PLANNING AND INFRASTRUCTURE

2 June 2025

Re: State Significant Development Application Number SSD-63324208
Novus - Build to Rent: 410-416 Victoria Avenue, Chatswood

I am writing to you regarding the State Significant Development Application Number SSD-63324208 at 410-416 Victoria Avenue, Chatswood; Council's submission is attached.

PROJECT NOVUS ON VICTORIA 410-416 VICTORIA AVE CHATSWOOD DRAWING TITLE GROUND FLOOR PLAN 1:100@A1

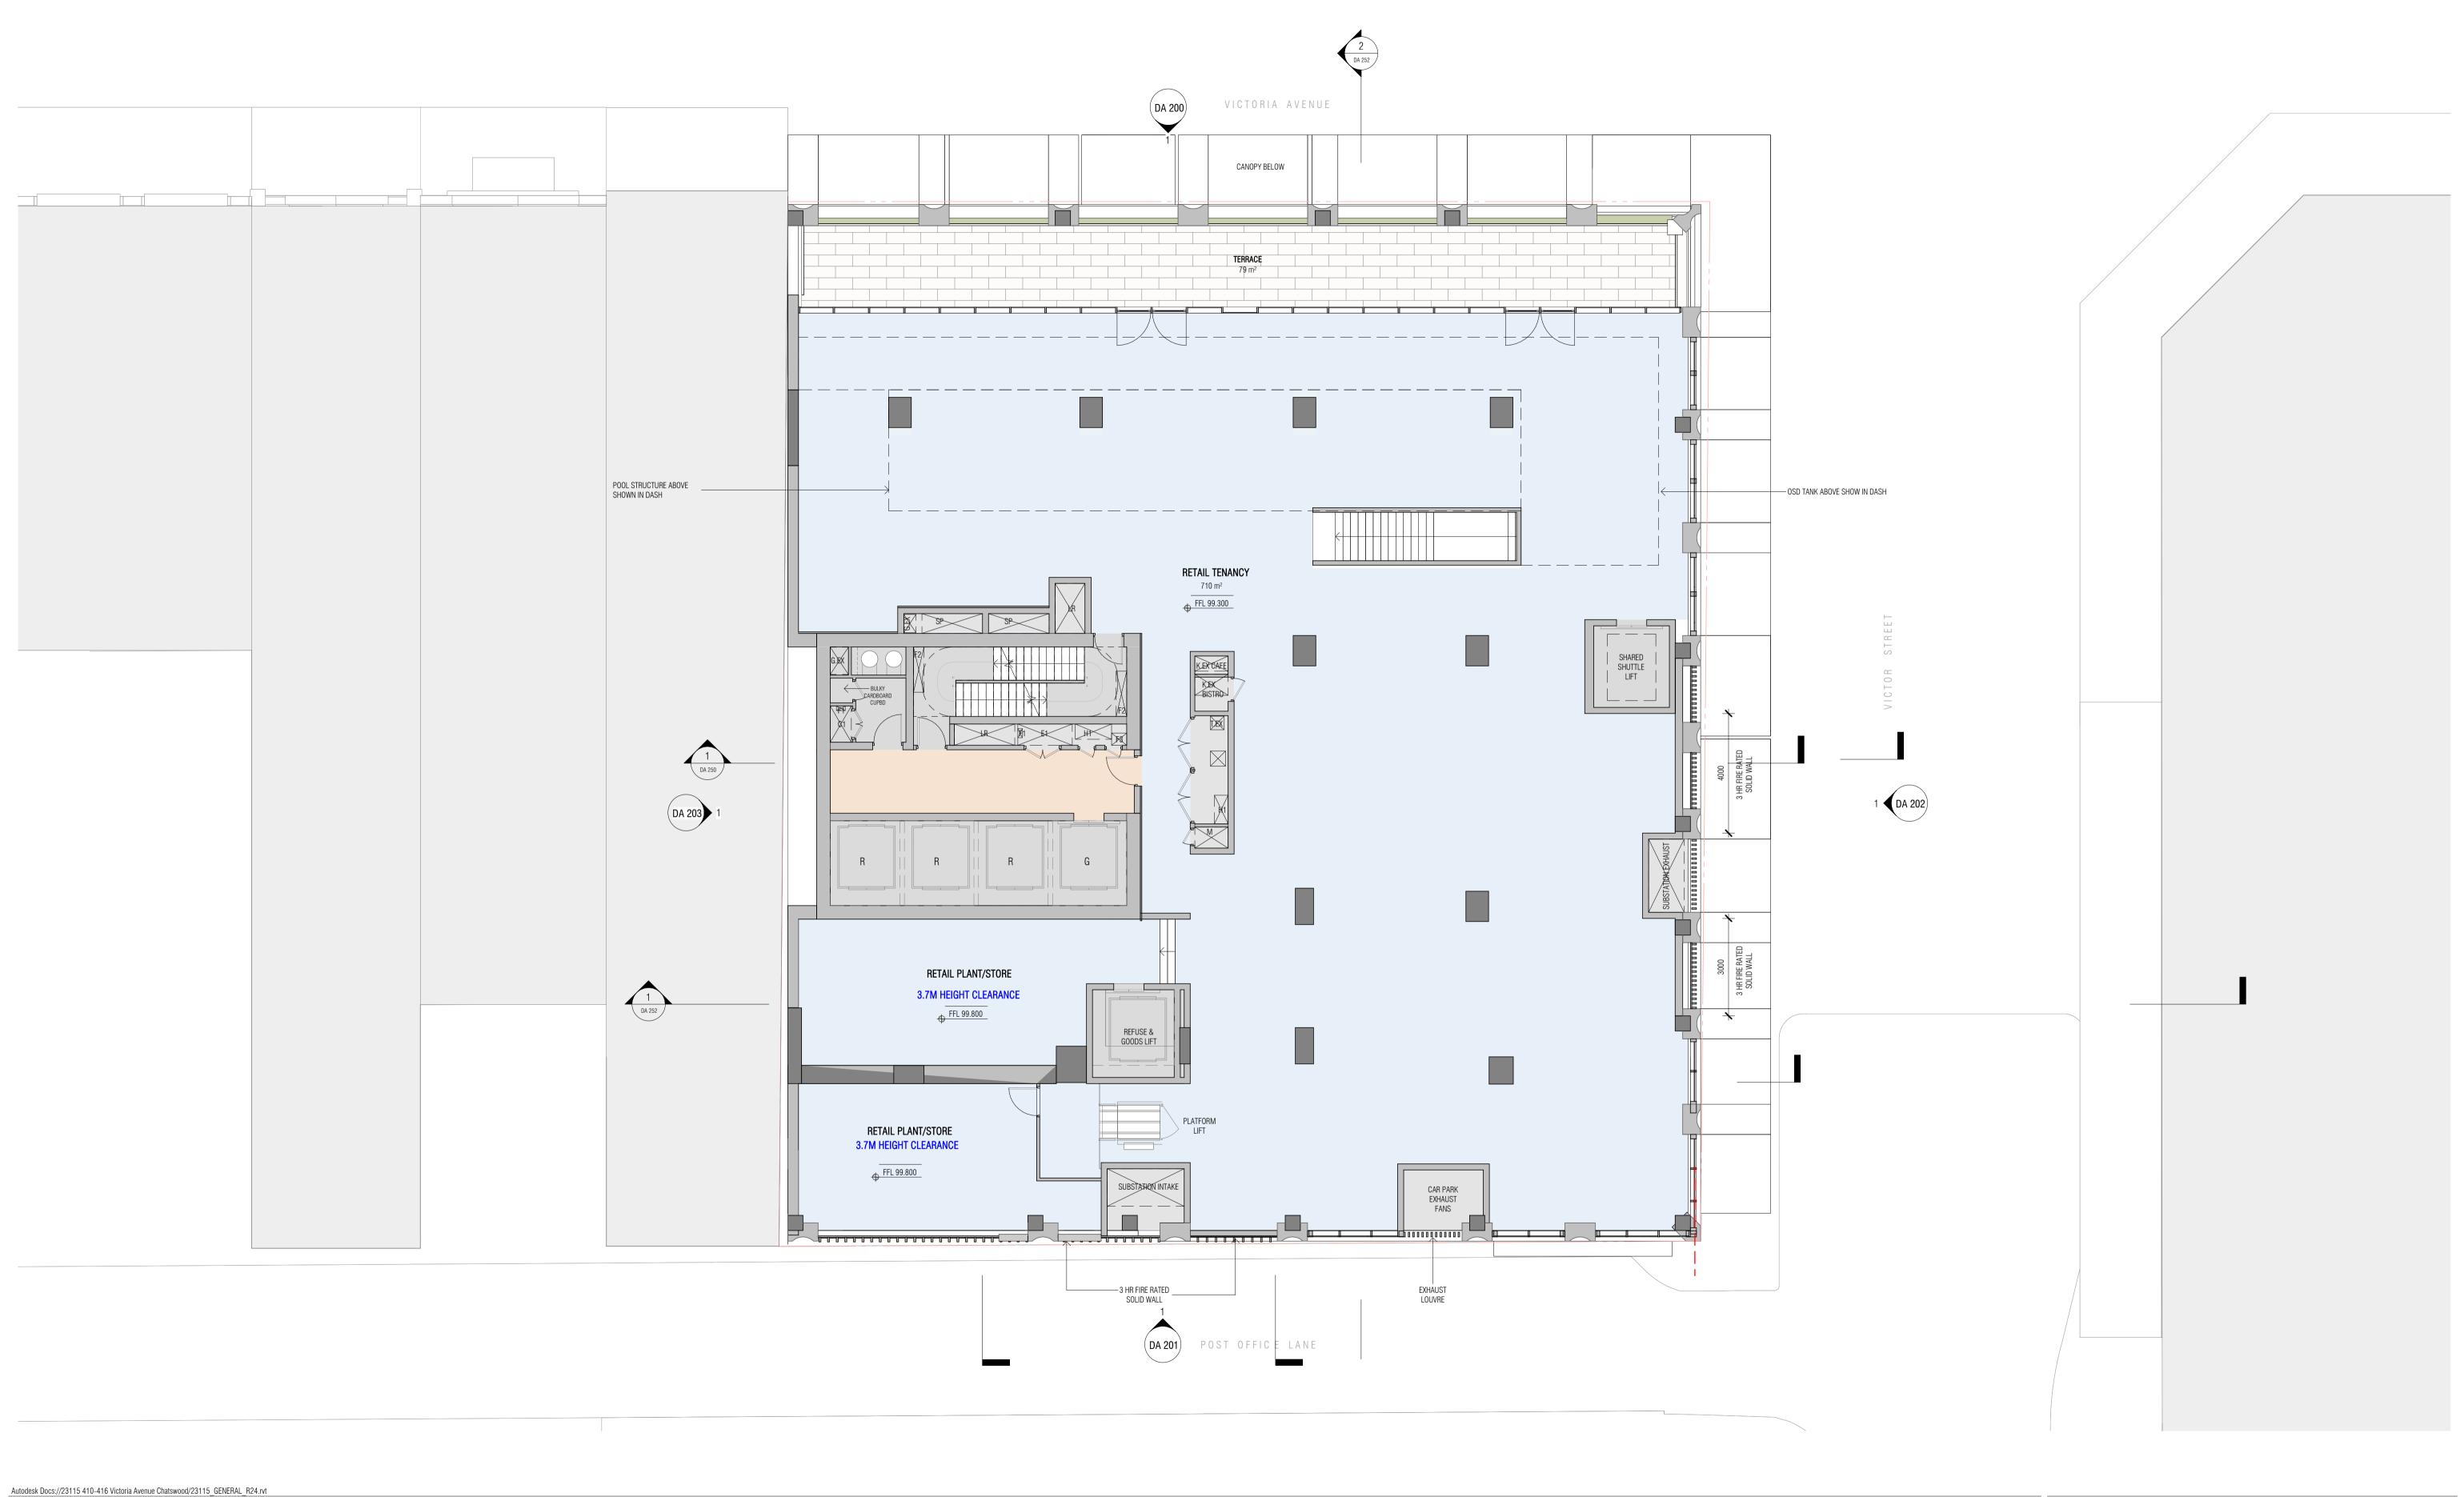
Council officers do not support vehicle access and the unloading/loading space off Post Office Lane.

Post Office Lane experiences up to 14,000 pedestrians a day. It is also used for servicing vehicles for surrounding properties and an emergency access route for the residential towers above the station. Council officers seek a solution for the pedestrianisation of Post Office Lane to significantly improve pedestrian access and safety, whilst ensuring vehicle access is maintained to surrounding properties.

The proposed development does not provide acceptable arrangements for waste disposal. Council does not support the collection of residential waste from a private operator. Vehicle access from Post Office Lane and the location of the turntable does not provide the ability for a Heavy Rigid Vehicle (HRV) to enter and collect waste from the site. The loading dock is not capable of providing a safe and practical arrangement for waste collection vehicles. There are a number of issues regarding the waste storage areas, location of waste chutes, and requested amendments to the construction and demolition waste plan.

EAST ELEVATION - TOWER

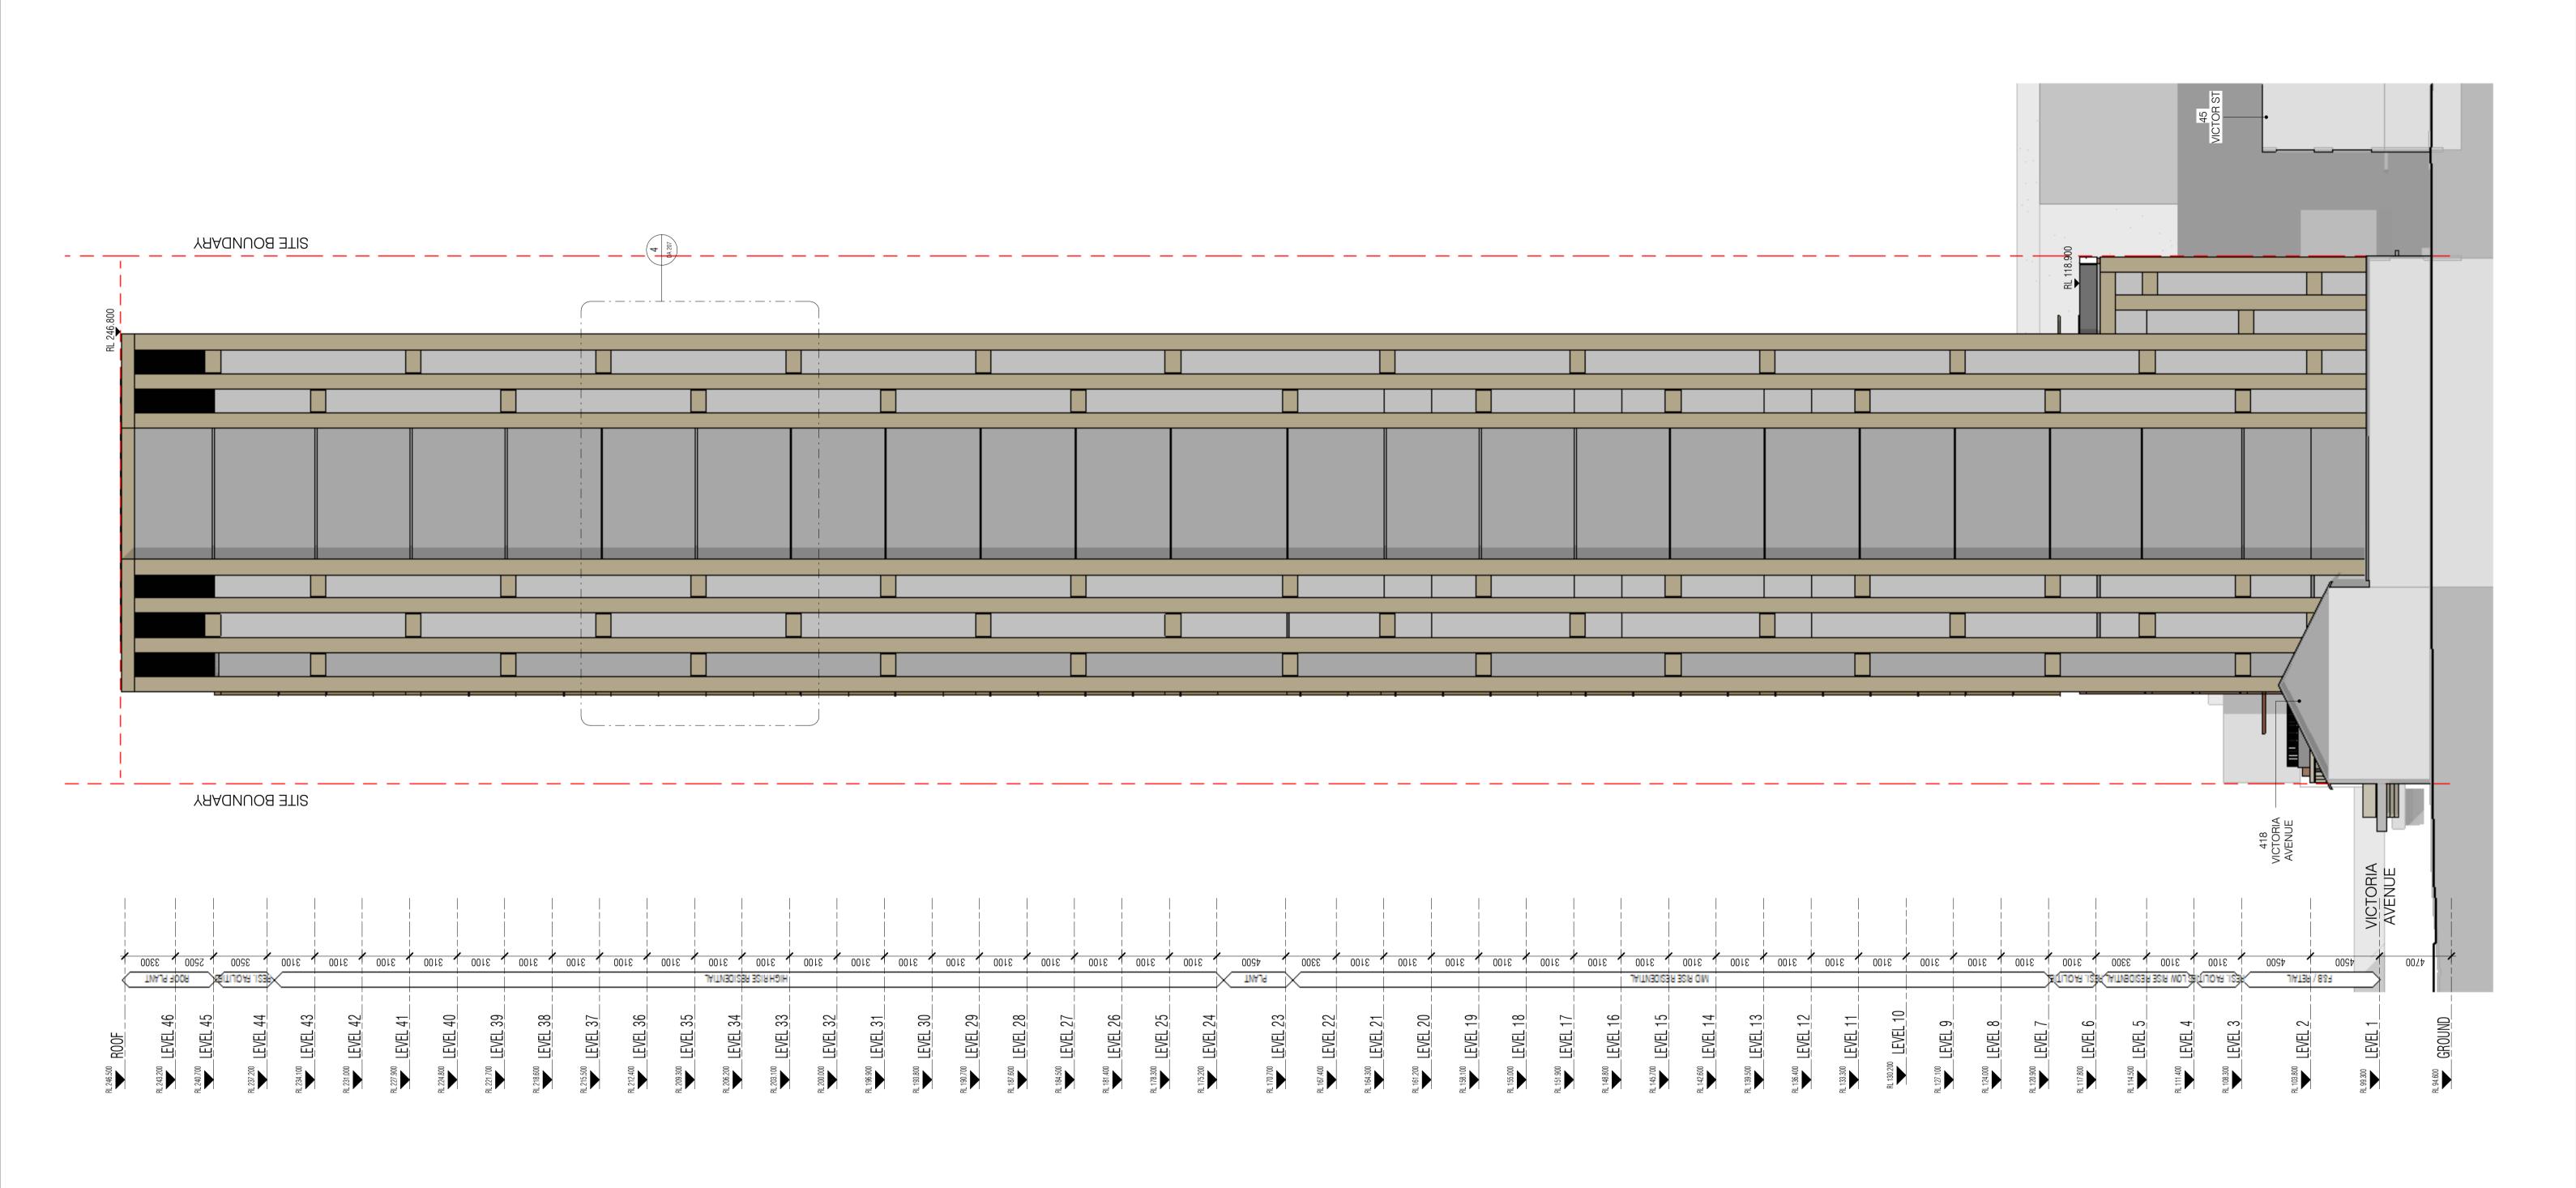
It is Council's view that a smaller floorplate should be proposed to ensure the impacts of the previously mentioned overdevelopment issues are minimised. A tower setback is required to the western boundary (no tower setback is proposed).
